Charlotte Department of Transportation

Memorandum

Date: May 1, 2008

Subject: Rezoning Petition 08-091: Located on the east side of Statesville Road between West W.T. Harris Boulevard and Metromont Parkway.

TECHNICAL DATA SHEET

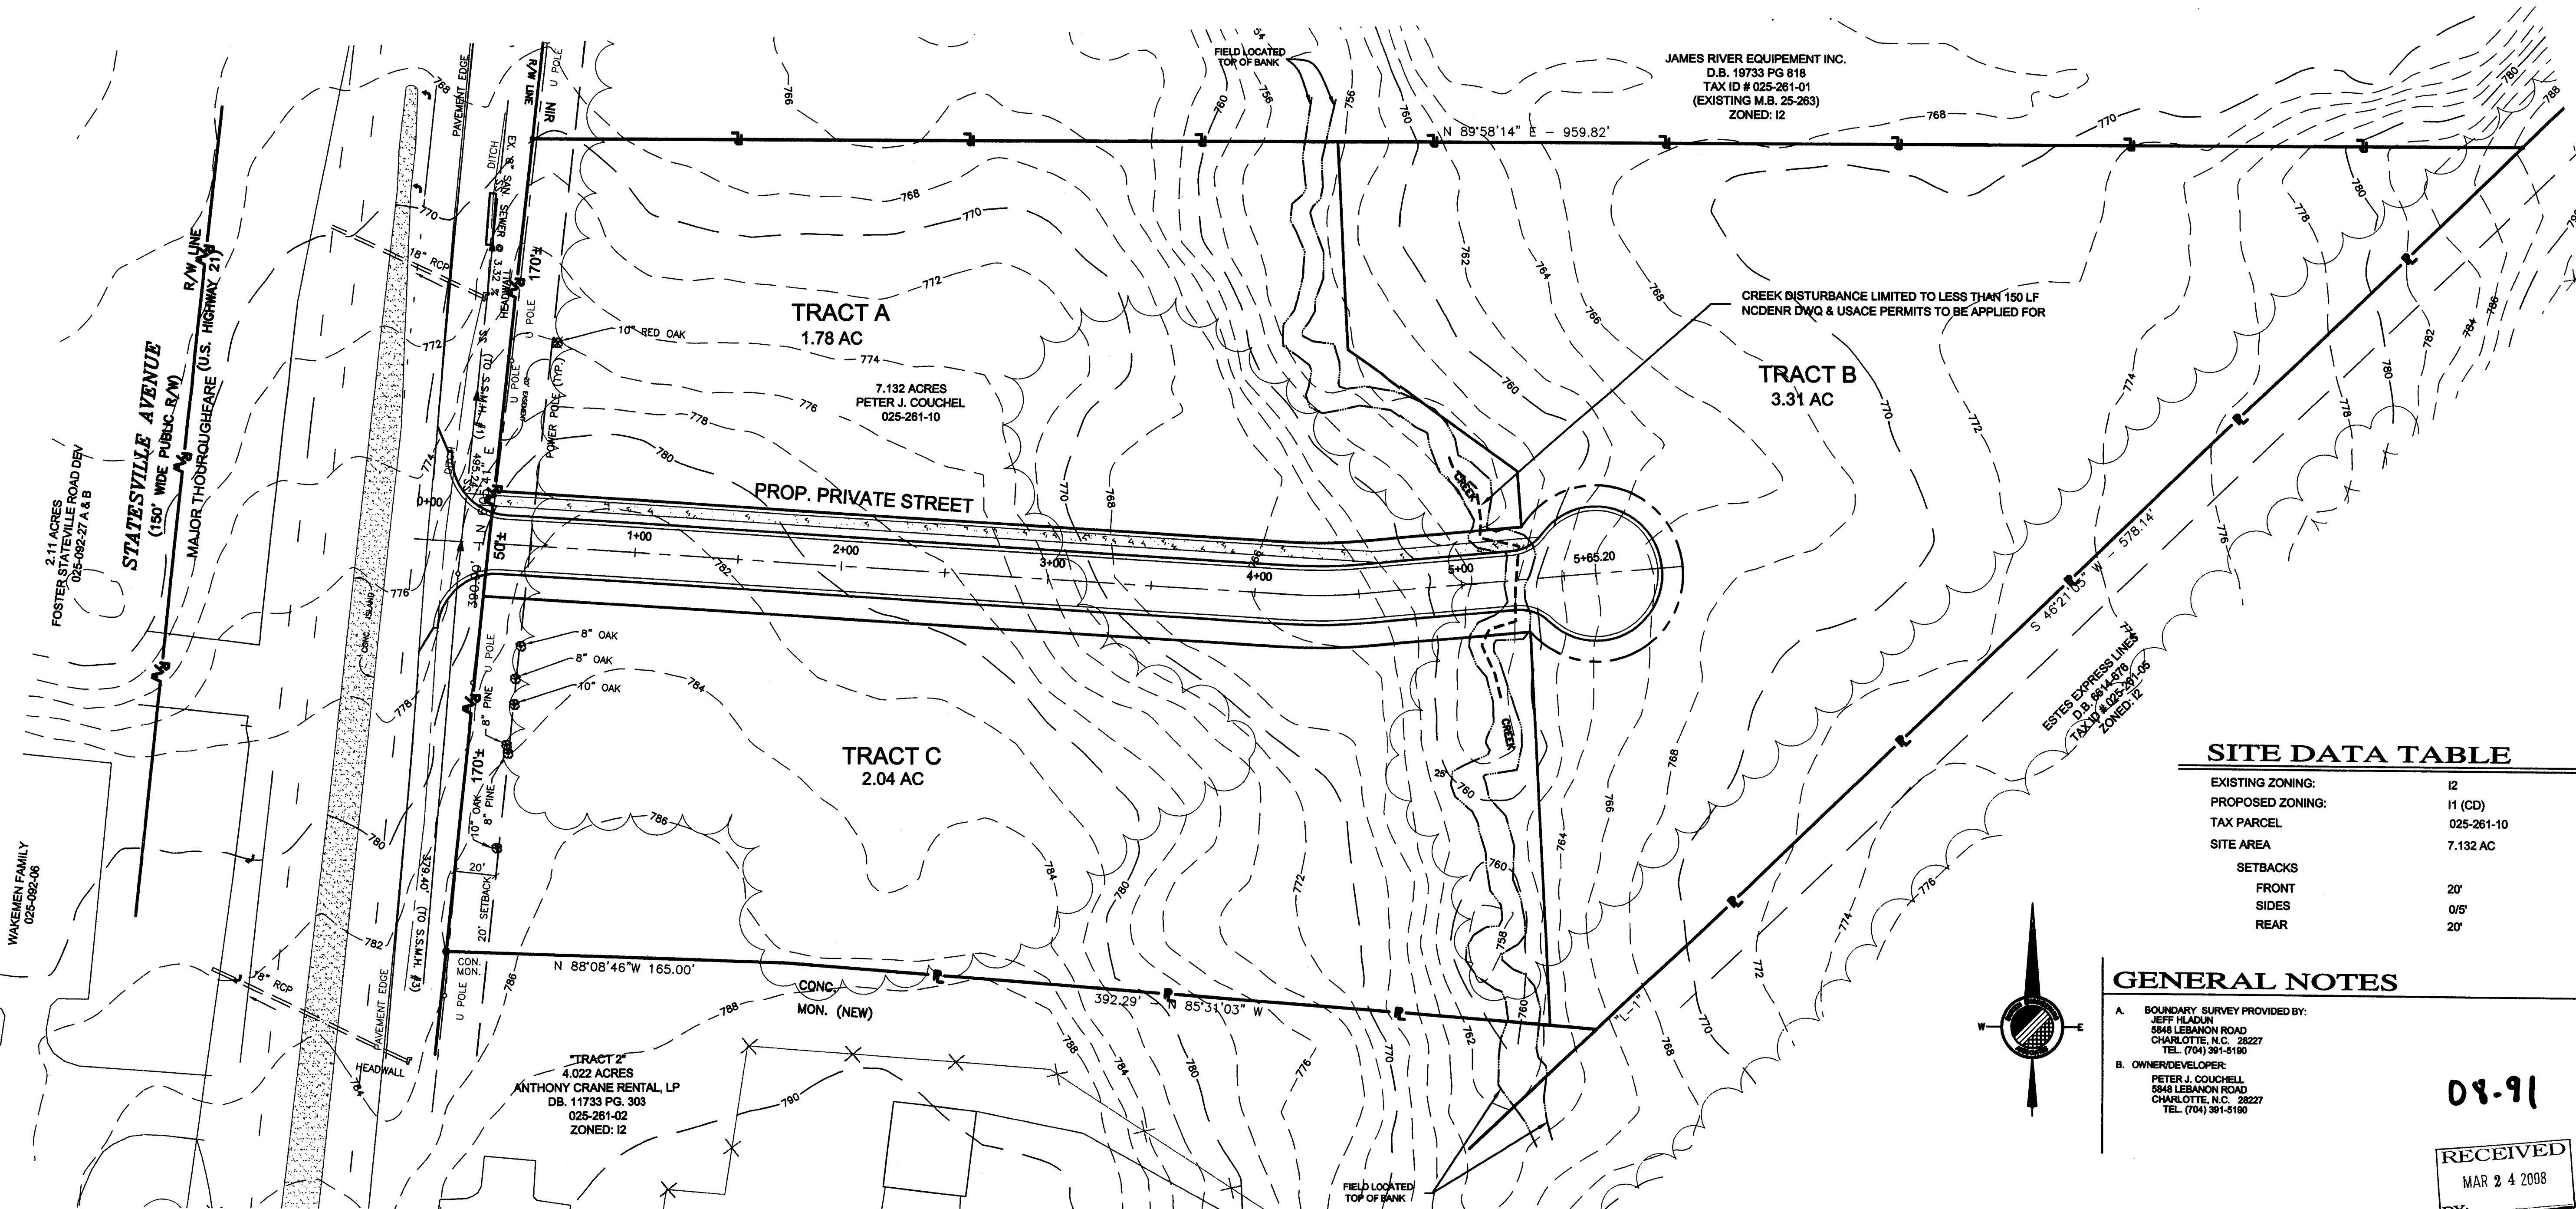
1. The site's proposed access is located in a median divided section of Statesville Road and will be limited to right-in/right-out movements only. All additional access to the site is to be

internal; no additional access onto Statesville Road from Tract A or Tract C will be permitted. This needs to be noted on the site plan.

2. Curb and gutter is required along the site's frontage on Statesville Road. CDOT will determine the location of the new curb and gutter based on the future cross section for the roadway during either the subdivision or commercial building/driveway permit process. Pavement transitions between new curb/gutter and existing edge of pavement sections are required to be designed/constructed at a 2:1 rate.

3. The developer needs to provide 8-foot planting strips and 6-foot sidewalks along Statesville Road, as measured from the future curb line. Statesville Avenue is a major thoroughfare requiring a minimum 100 feet of right of way. This section of Statesville Avenue has an existing right-of-way of 150 feet to accommodate the future median divided cross section. The existing roadway was originally constructed in the location of the future northbound lanes and for this reason is not in the middle of the right-of-way. Until the future median divided cross section is constructed, an easement may be required to accommodate the required planting strip and/or sidewalk.

4. The proposed private street needs to be constructed as a public street and stubbed at the eastern property line so that it may be extended in the future. This street needs to be designed as a Local Industrial Street with a back-of-curb width of 35 feet, 8-foot planting strips, and 5-foot sidewalks (61' right-of-way) in accordance with the adopted Urban Street Design Guidelines.

5. The note on the plans that states, "Creek disturbance limited to less than 150 lf..." needs to be removed from the plan. Subsequent review phases will determine if the improvements will fall under the nationwide permit or if the developer needs to seek an additional NCDENR permit. This note restricts the design of the proposed street.

6. The second bullet in the Development Standards under "Transportation" needs to be revised to also include the Charlotte Department of Transportation.

1. Cross-access to the northern and southern properties needs to be accommodated on the site plan so that vehicles traveling between parcels do not have to use the thoroughfare. This can be done with platted access easements through the tracts.

Adequate sight triangles must be reserved at the proposed street entrance(s). Two 35' x 35' and two 10' x 70' sight triangles are required for the entrance(s) to meet requirements. All proposed trees, berms, walls, fences, and/or identification signs must not interfere with sight distance at the entrance(s). Such items should be identified on the site plan.
